Drafted 25 September 2012

**Planning Application, Ribble Valley District
3/12/0797 land at Southport House, Sawley**

LOCATION PLAN

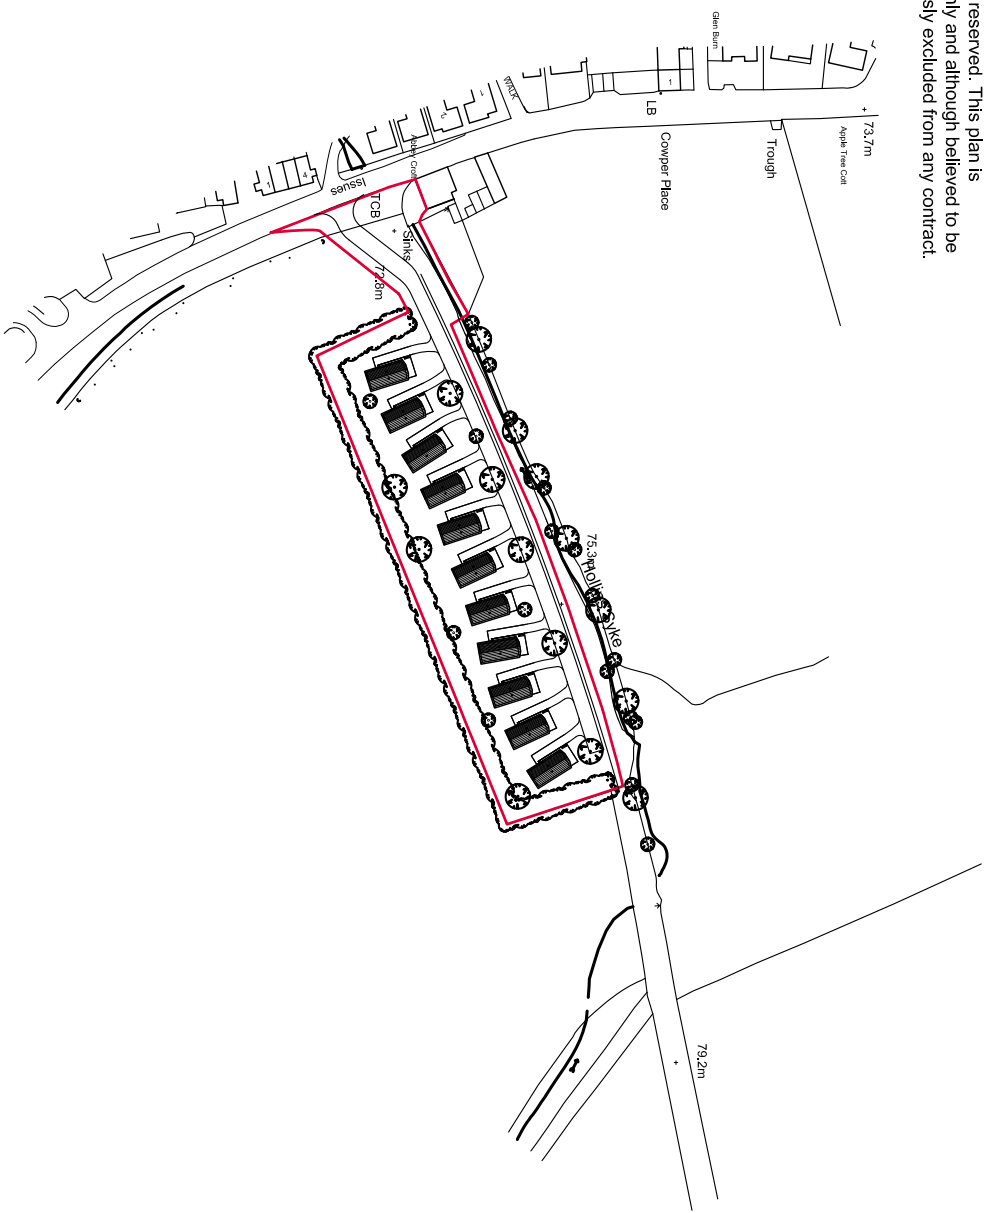
On exiting the site, visibility to the north of the site is restricted by the gable end of Southport House. I have estimated that a visibility splay of approximately 33m, when measured from 2.4m back from the edge of carriageway, can be achieved. Given that there is a 30mph Speed Limit in operation along Sawley Road, I am not satisfied that this is consistent with the SSD (stopping sight distance) set out in Manual for Street 2 and is therefore not acceptable.

However, I accept that I have not surveyed the site access in detail and rather than recommend refusal at this time, I would welcome further discussions or detailed submissions from the applicant concerning this visibility splay.
